Our ref: HA/2014/116257/01-L01
Your ref: BE/121/14/DOC
Date: 22 October 2014

APPLICATION FOR APPROVAL OF DETAILS RESERVED BY CONDITIONS 5 AND 10 IMPOSED UNDER BE/73/14/PL RELATING TO SURFACE WATER DRAINAGE.

LAND AT OLDLANDS FARM SHRIPNEY ROAD BOGNOR REGIS PO22 9NN

Typical Separator + Rainwater Harvesting Tank Installation Detail (Scale 1 : 50)

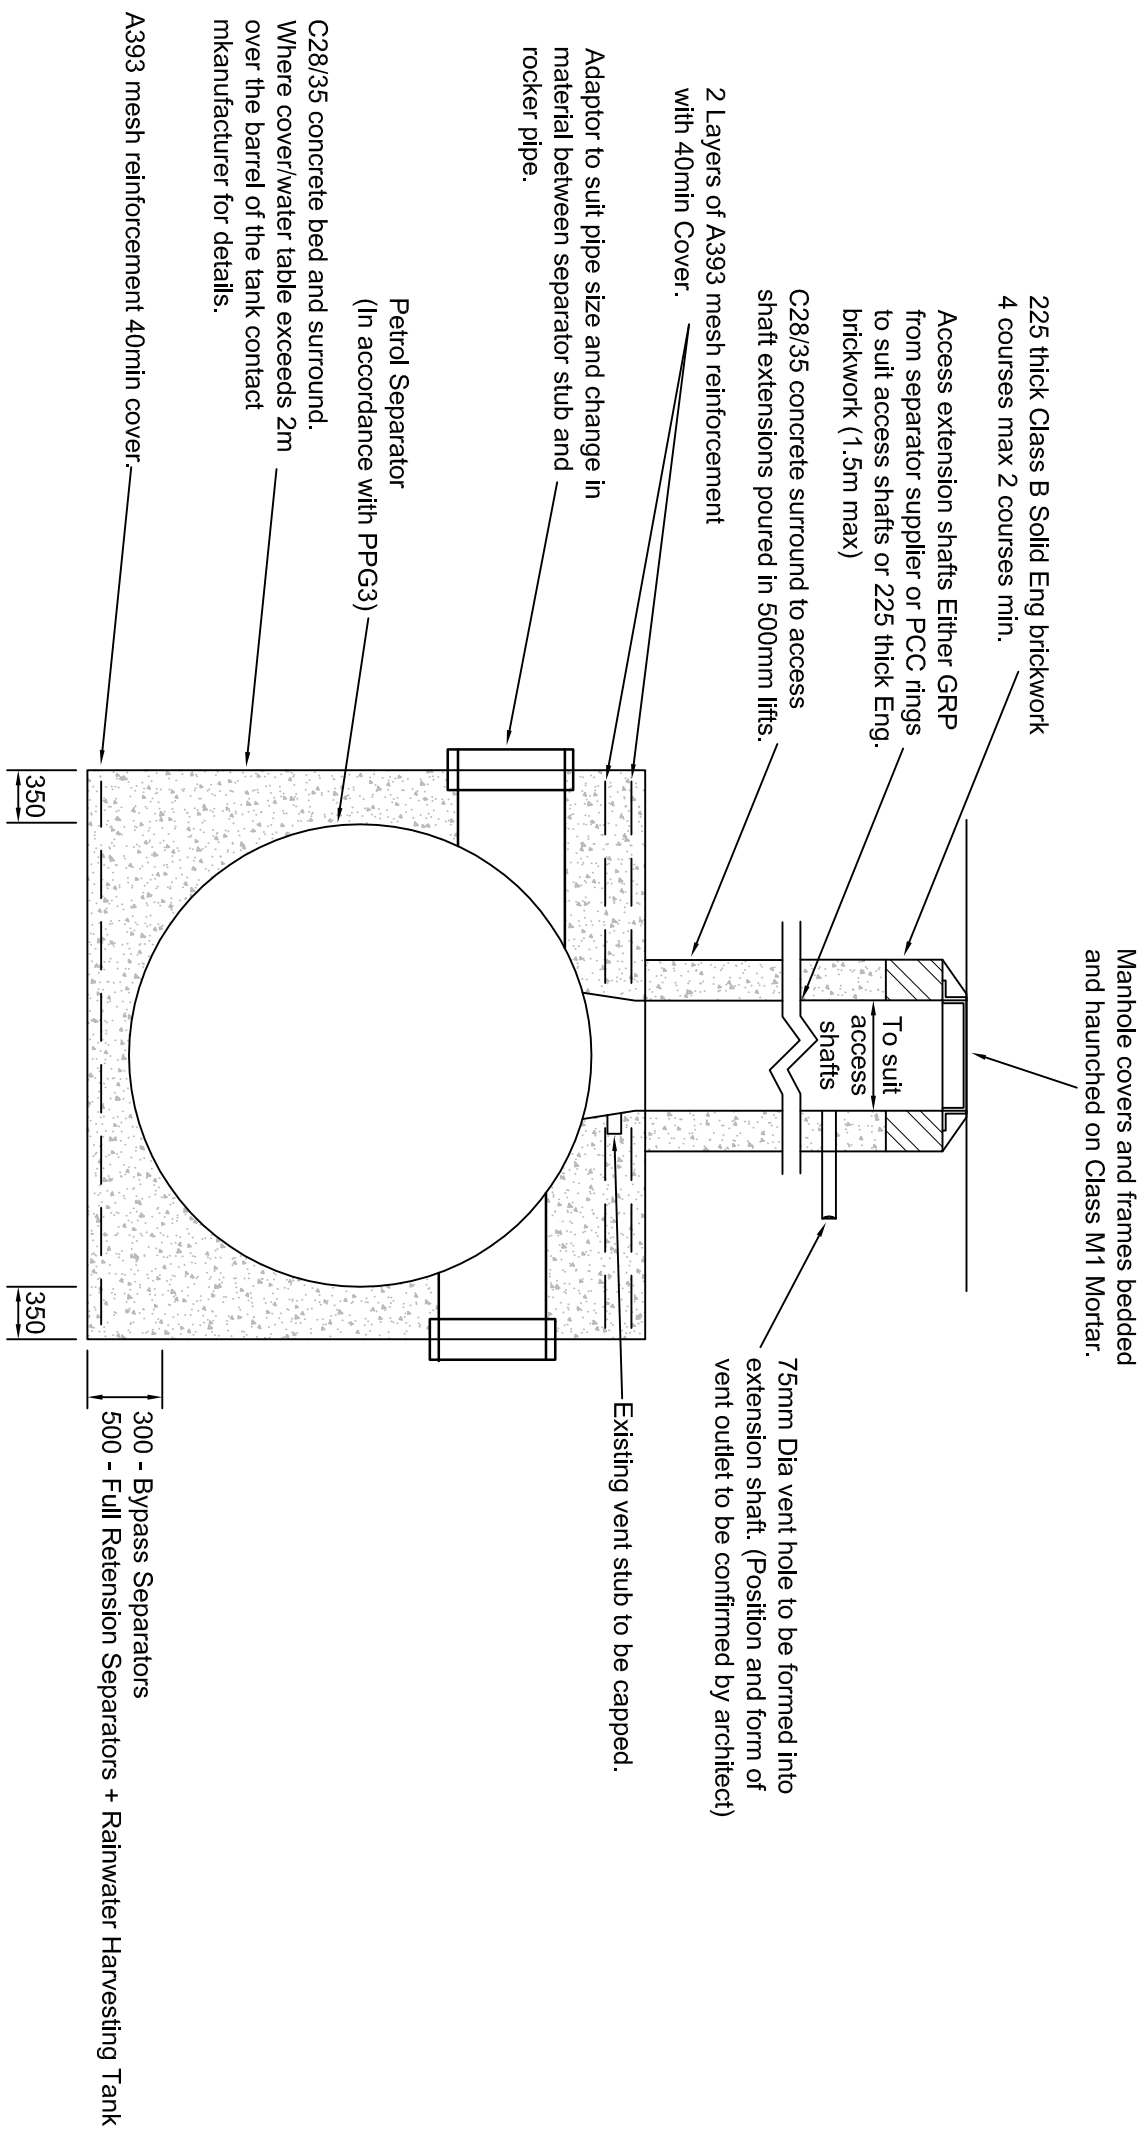
We have reviewed the Drainage Strategy details produced by Hydrock (Hydrock Phase 1 Drainage Condition Report Ref: R/14443/009). We agree with the pollution prevention measures including the installation of a petrol separator. We recommend that the separator is a Class 1 design with a coalescer filter with an alarm.
